WEST SUSSEX COUNTY COUNCIL CONSULTATION

TO:	Arun District Council FAO: Simon Davis
FROM:	WSSC – Lead Local Flood Authority
DATE:	21 st November 2019
LOCATION:	Land east of Shripney Road & south of Haddan House Shripney Road Bersted PO22 9NW
SUBJECT:	BE/109/19/OUT Outline application with some matters reserved for up to 46 No dwellings together with access. This application is a Departure from the Development Plan & may affect the character & appearance of the Shripney Conservation Area
RECOMMENDATION:	Advice – No objection

V:\Server DATA\PROJECT FILES\1948 Land East of Shripney Rd\Landscape\Drawings\Sketch\DLA.1948.L.06.S - Cad Layout Plan\DLA.1948.L.06.S08 Cad Layout Plan.dwg

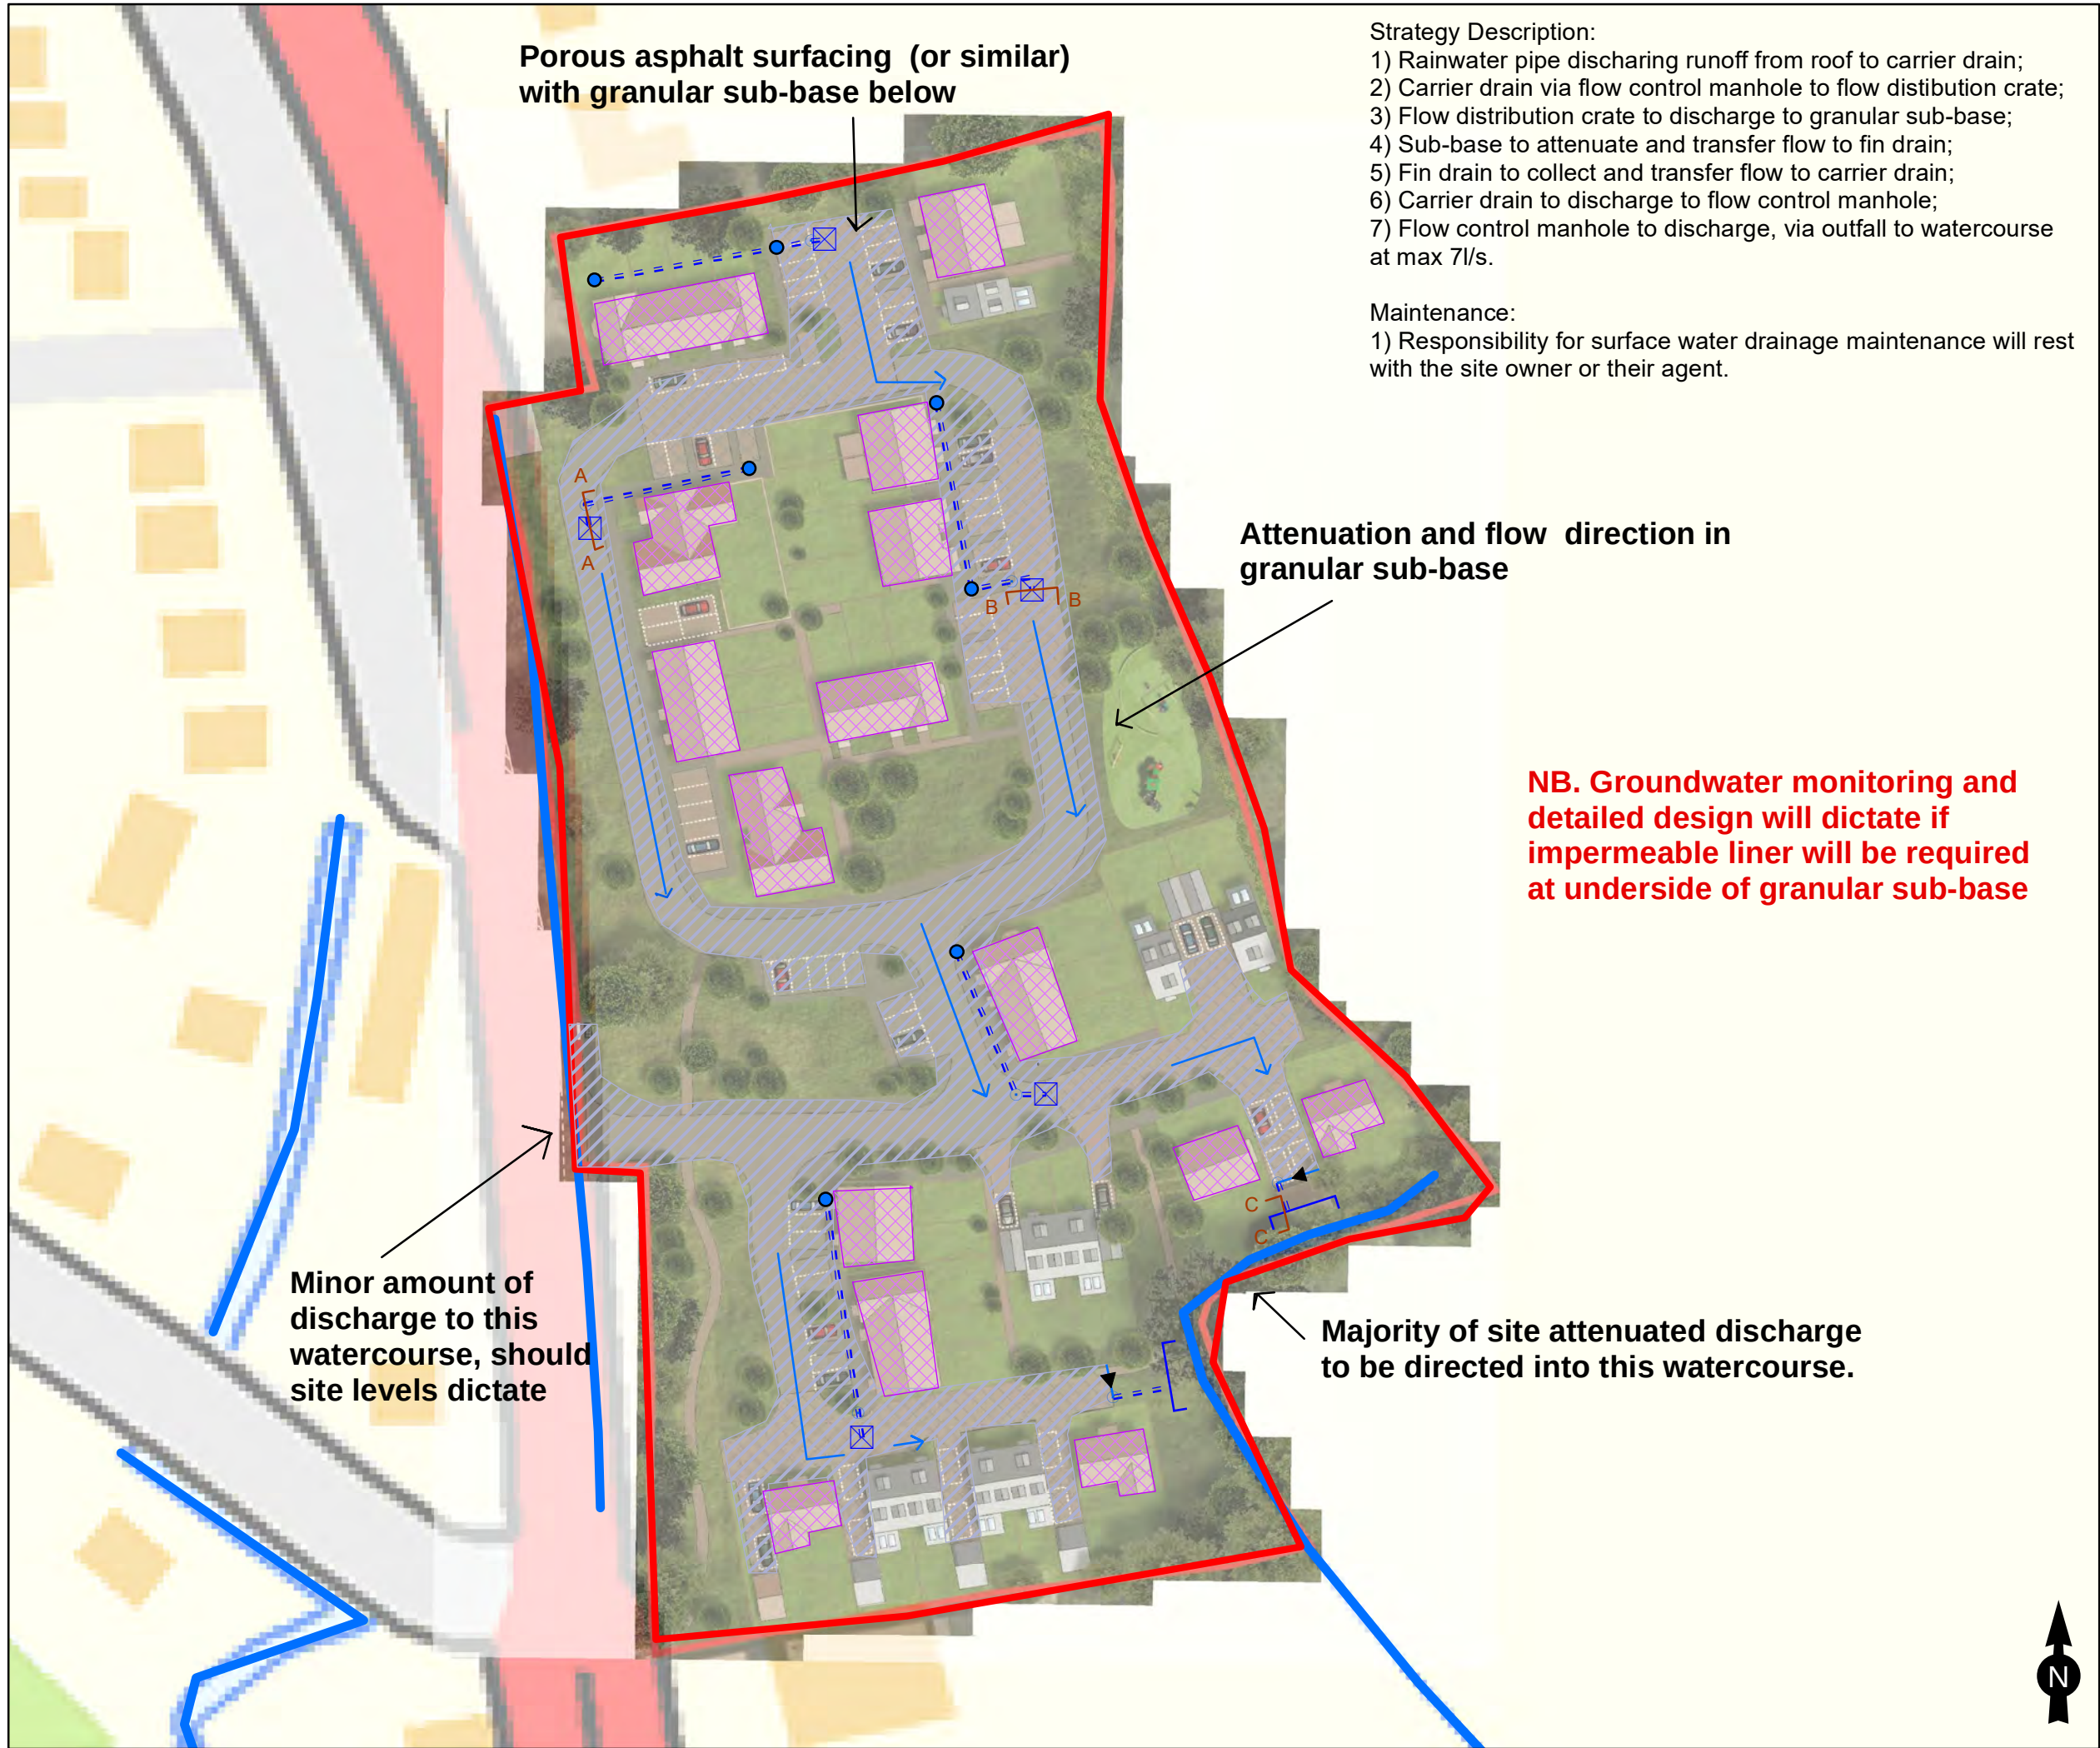
The Flood Risk Assessment for this application proposes that sustainable drainage techniques (permeable paving and below ground attenuation with a restricted discharge to the watercourse) would be used to control the surface water from this development.

Following the SuDS hierarchy and the spirit of SuDS implementation, betterment for surface water systems on the new developments should be sought. This could include retention at source through green roofs, rain gardens, swales and above ground attenuation prior to disposal to reduce peak flows. SuDS landscaping, could significantly improve the local green infrastructure provision and biodiversity impact of the developments whilst also having surface water benefits.

As indicated by the District Engineer, improvements to the adjacent ditch network may be required to enable the proposed system to function correctly.

All works to be undertaken in accordance with the LPA agreed detailed surface water drainage designs and calculations for the site, based on sustainable drainage principles. The drainage designs should demonstrate that the surface water runoff generated up to and including the 1 in 100 year, plus climate change, critical storm will not exceed the run-off from the current site following the corresponding rainfall event.
